WELWYN HATFIELD BOROUGH COUNCIL – DEVELOPMENT MANAGEMENT
DELEGATED REPORT

APPLICATION No:	S6/2012/2622/LB
APPLICATION Site:	Oshwal Centre, Coppers Lane Road

The application proposes the erection of a single storey rear extension following demolition of existing ground floor extension and enlarged terrace area.

PROPOSED GROUND FLOOR

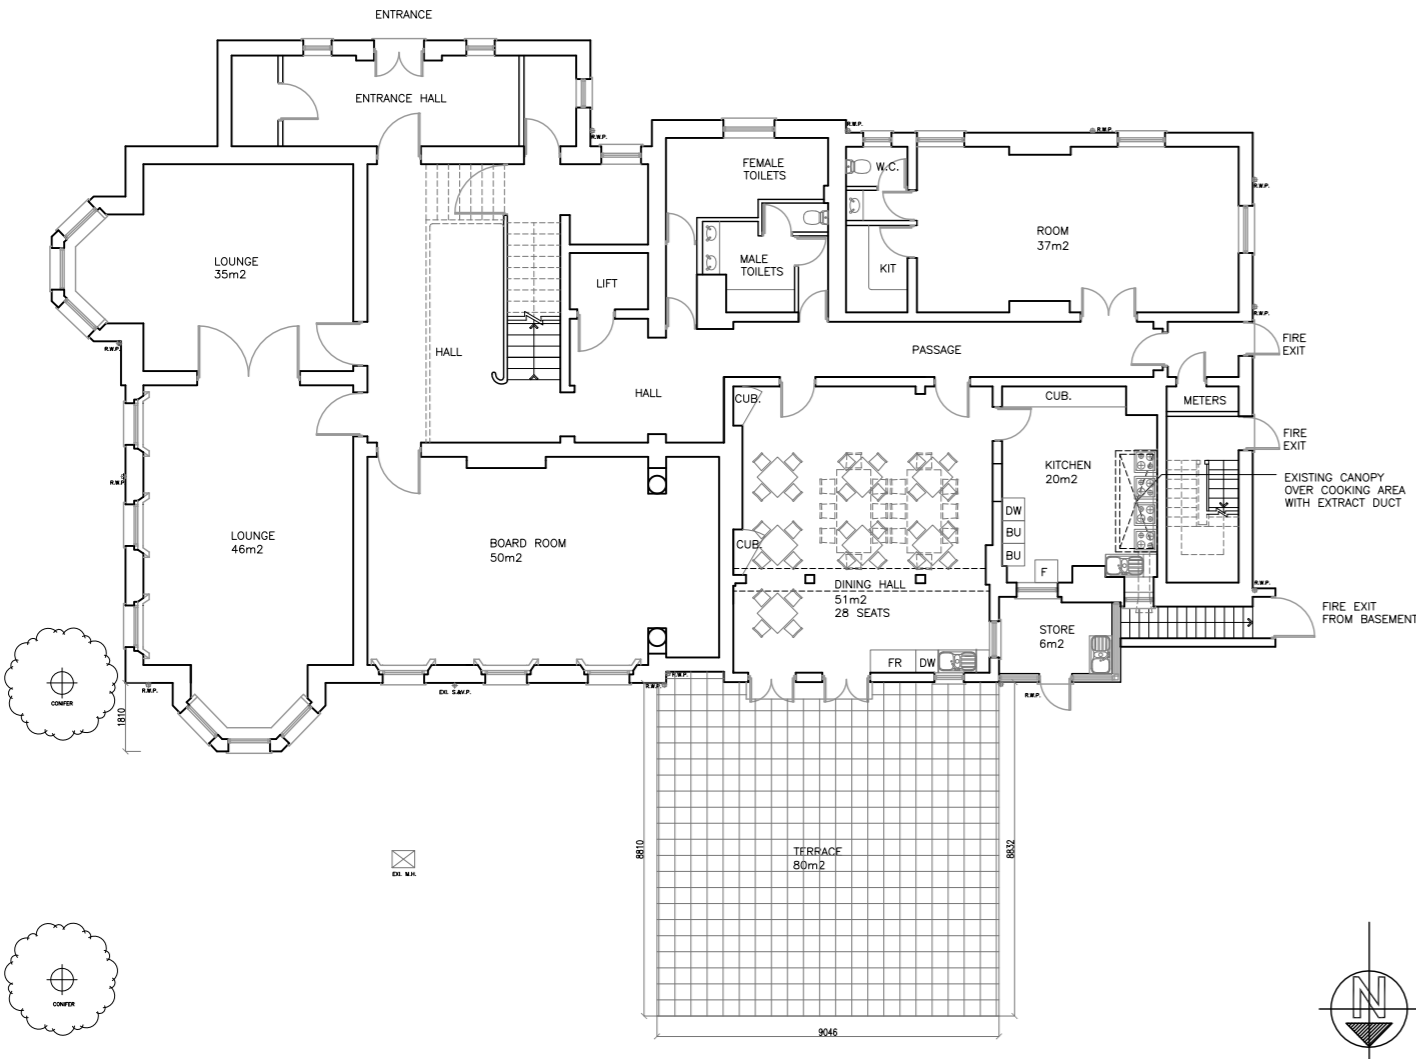
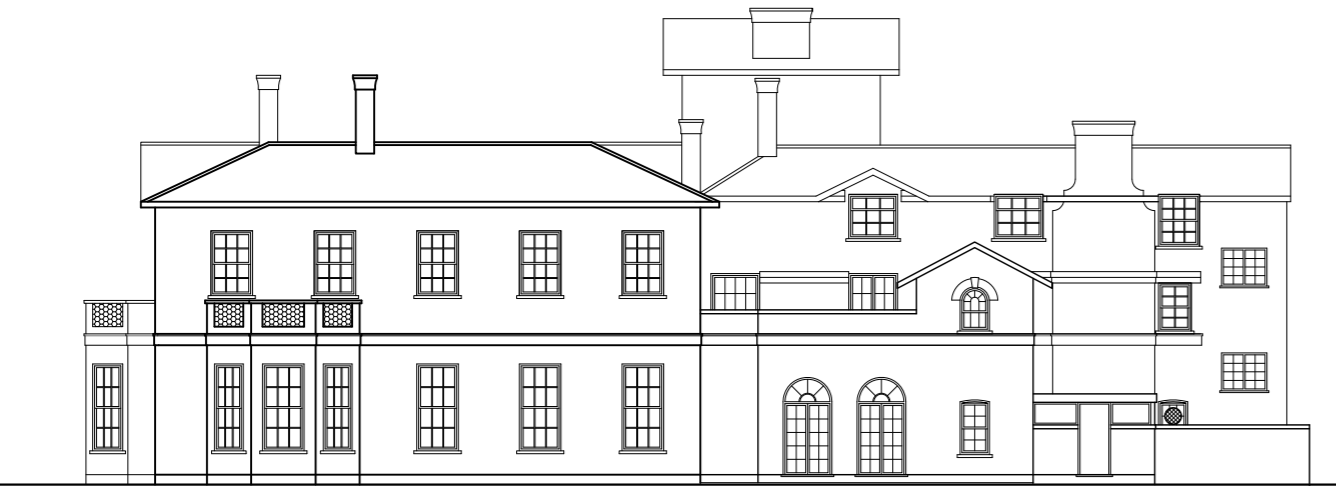
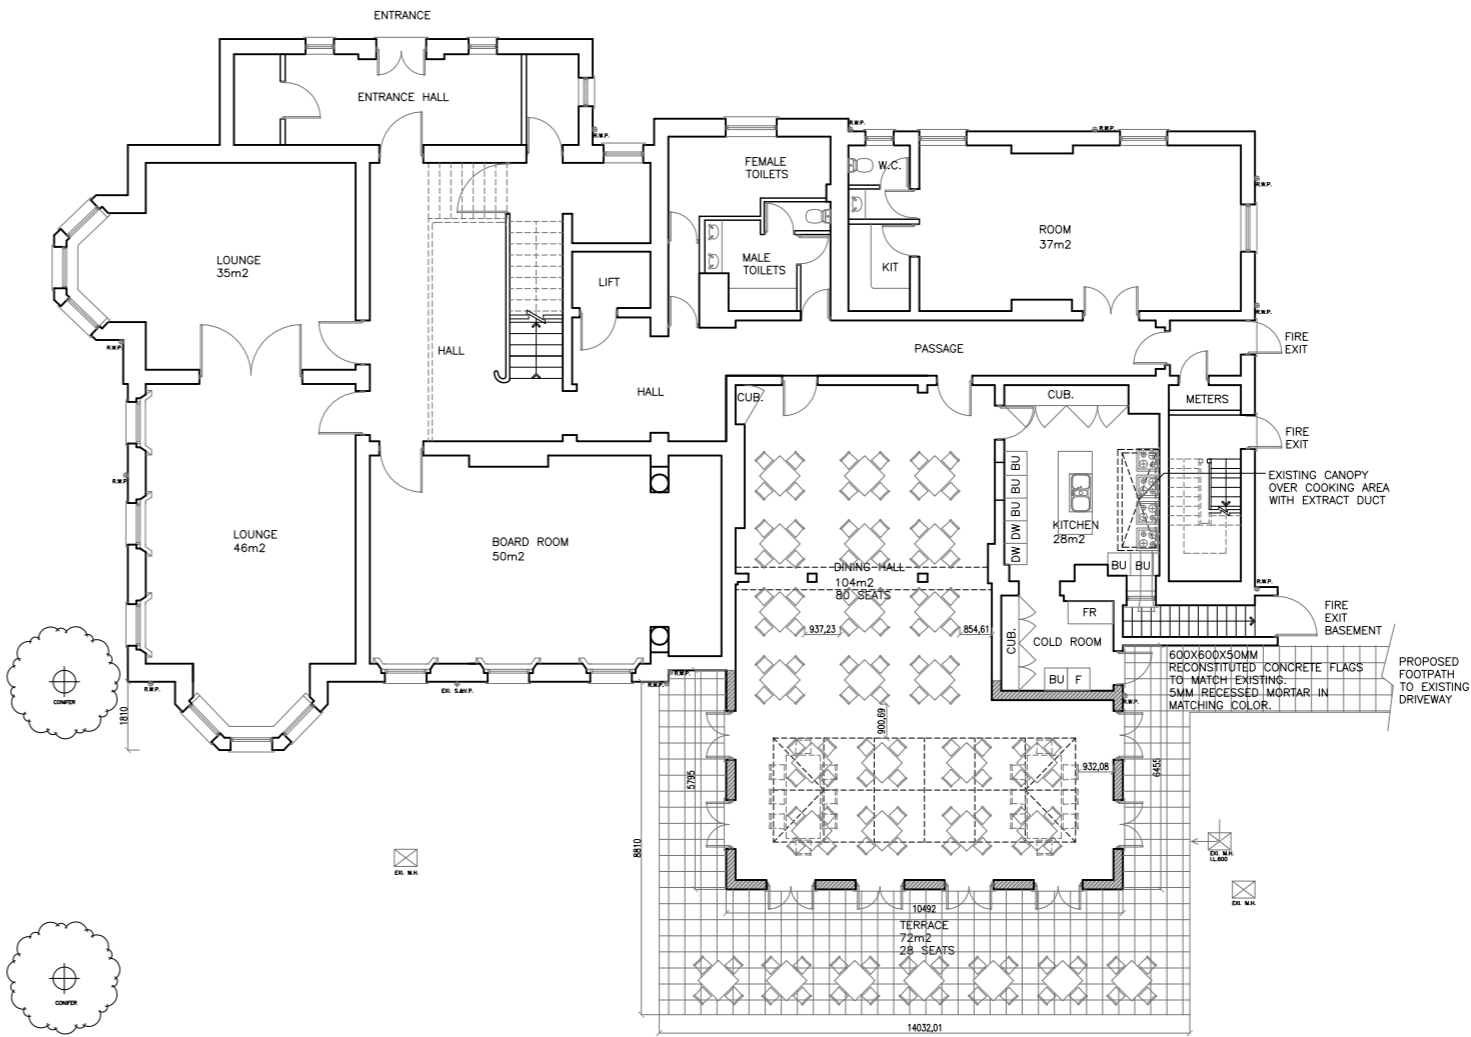
The design of the new extension will require the removal of an existing rear wall which currently has two arched opening where full height glazed patio doors exist. There is also a requirement to remove a small flat roofed extension and to increase the opening size of an existing window.

There is evidence in the planning history to show that the wall to be demolished is a much more recent addition granted by application S6/352/84 and so is not part of the original fabric of the building. The loss of these features is therefore not considered to be an issue to this heritage asset. Furthermore, the proposed design will also replicate the features of the glazed windows which will be removed as part of this development.

In regards to the relationship between the new extension and the current building, the extension is to be located to the rear of the building where an outside terrace is currently located. The existing building has mainly pitched roofs, but there are existing examples of flat roofs, including the original bay windows. As such the use of a flat roof of this scale which also has a glazed lantern in its centre is not considered to be harmful to the overall character of the building.

In regards to the new windows and doors, further larger scale drawings are required to show the proposed joinery detailing and final finish. Likewise, the new glazed roof lantern will also need to be designed in more detail to shown that it will be of high quality and constructed of materials that are appropriate for a listing building. A planning condition to secure this would be reasonable along with the materials proposed for the new terrace area.

4. Prior to any building works being first commenced, detailed drawings to an appropriate scale of the new windows (including proposed roof lantern) and doors including a section of the glazing bars and frame moulding and clearly showing the position of the window frame in relation to the face of the wall,

depth of reveal, and sill details shall be submitted to, and approved in writing by the Local Planning Authority. The approved details shall then be implemented and retained unless otherwise agreed in writing by the Local Planning Authority.

PROPOSED ROOF PLAN

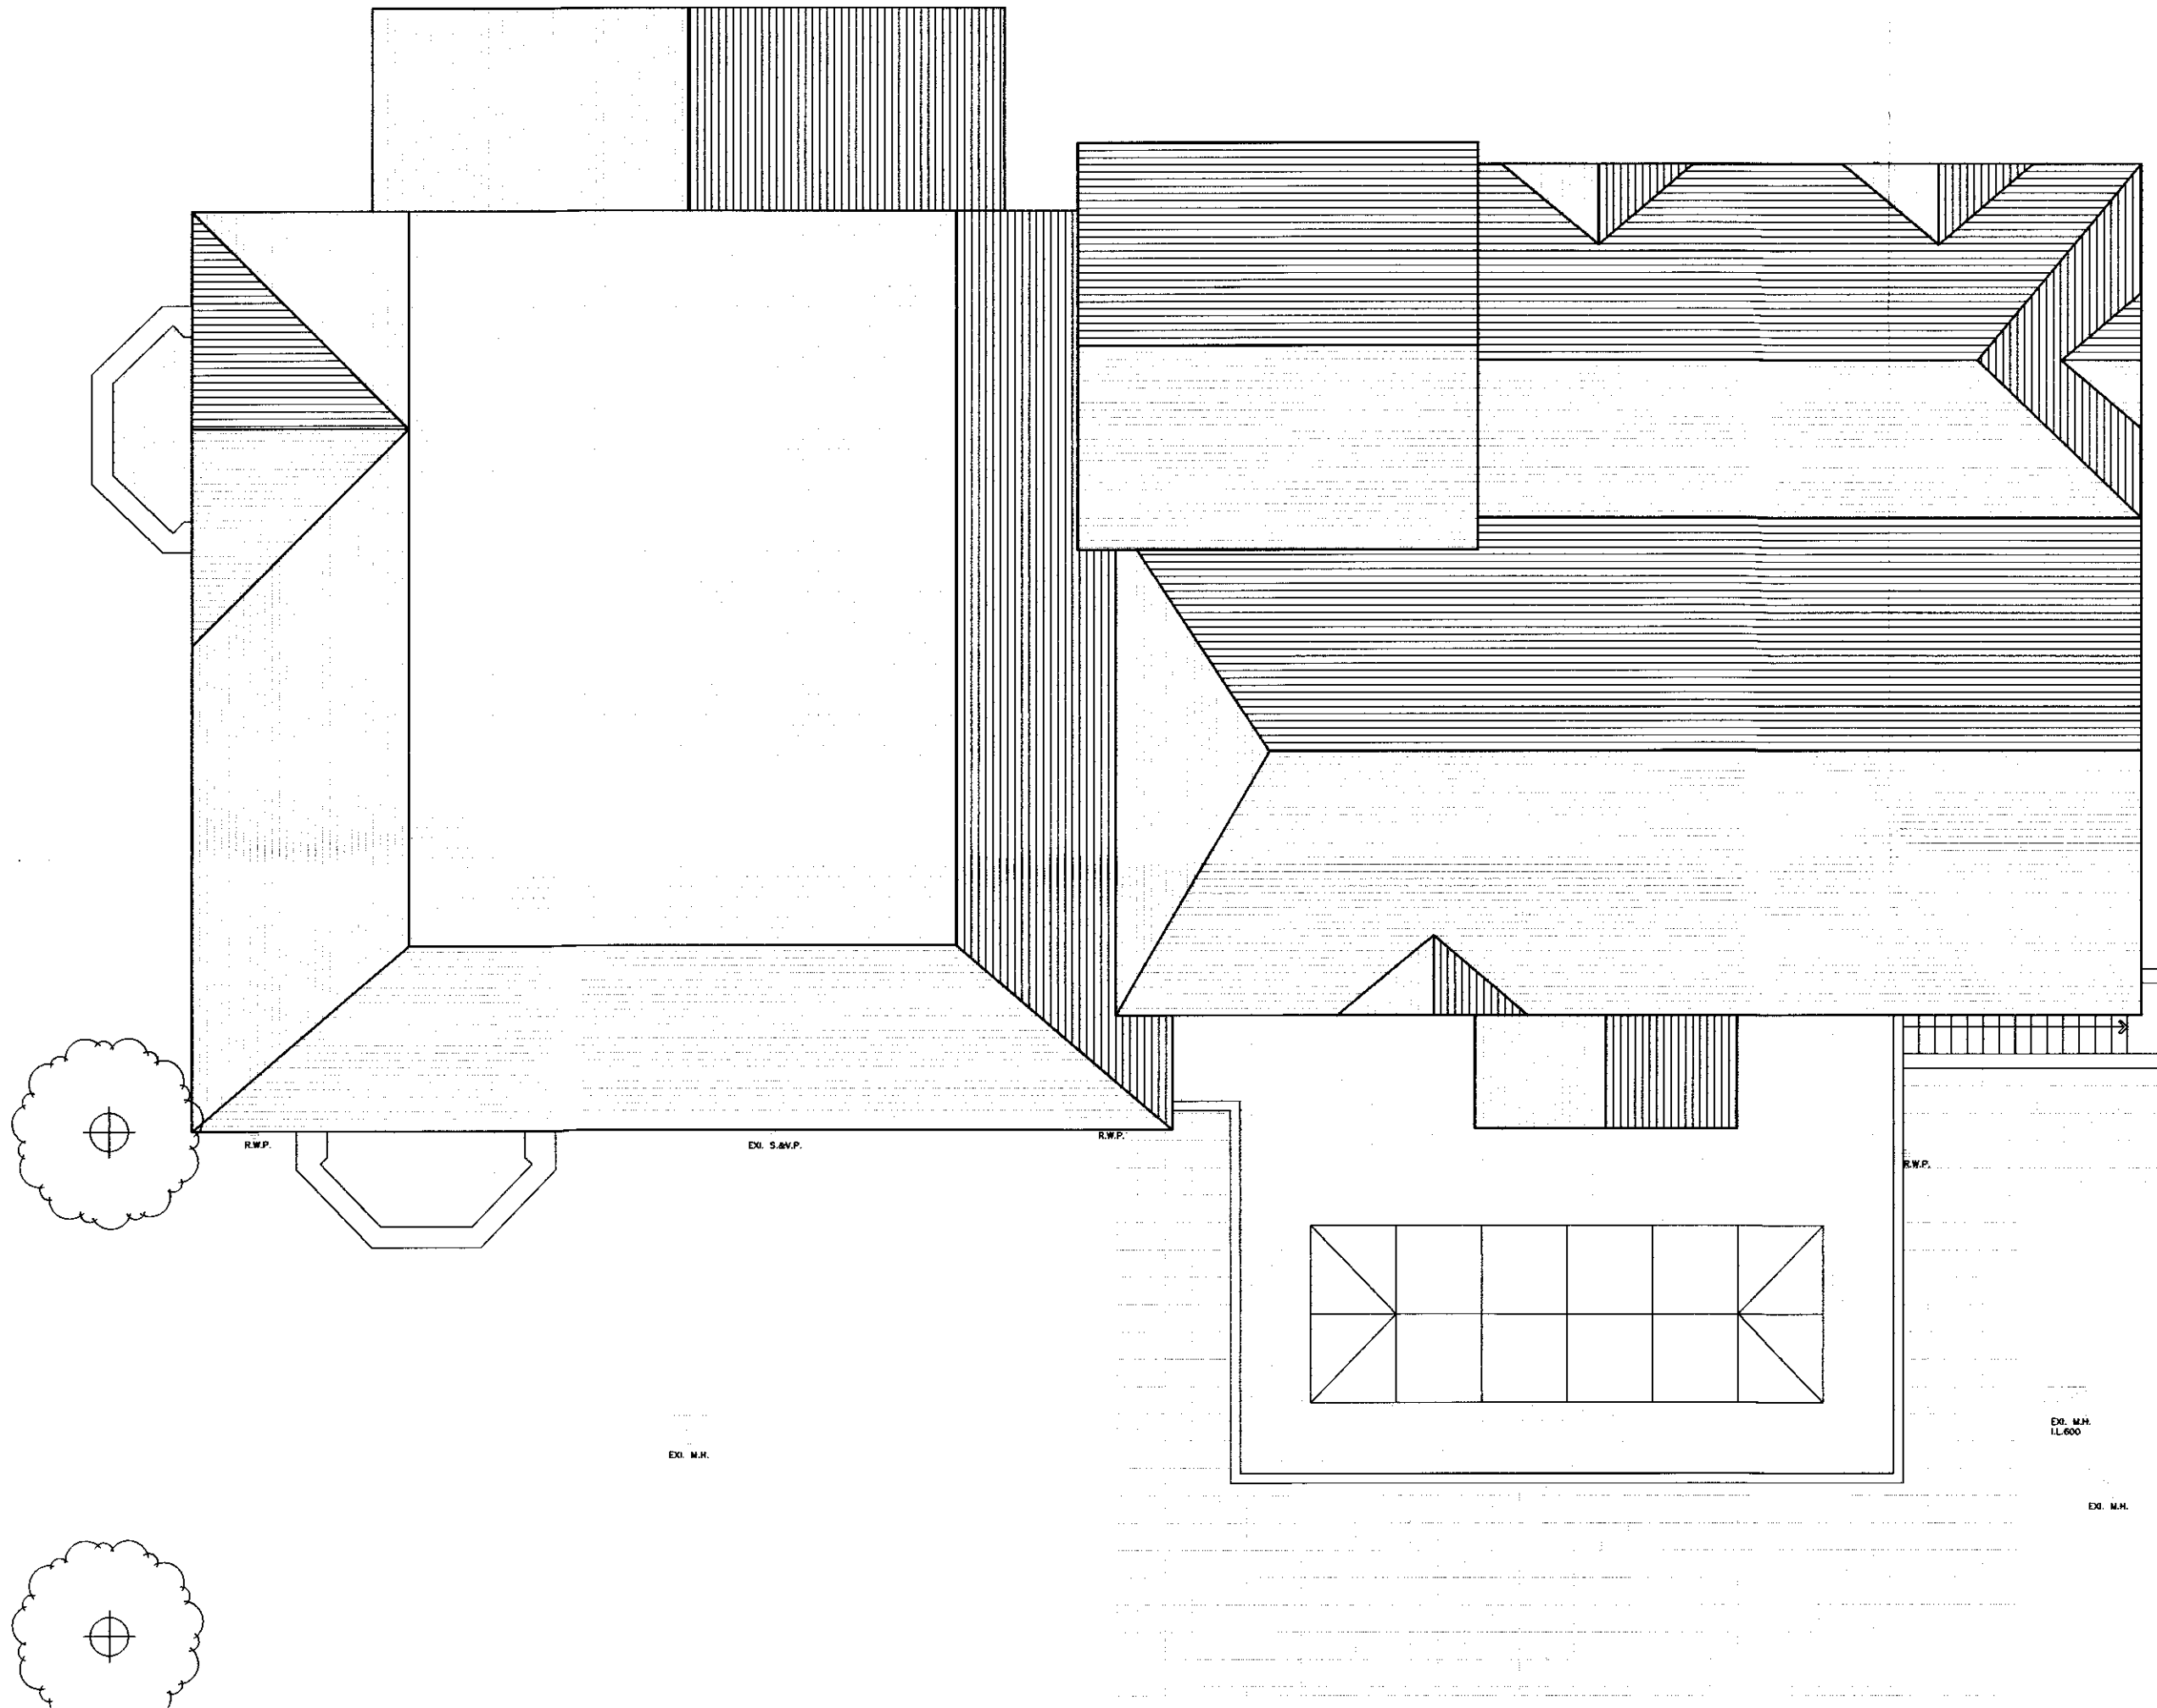
To facilitate this it is proposing to extend the existing flat roof and to create a central lantern to allow daylight into the centre of the new seating area.
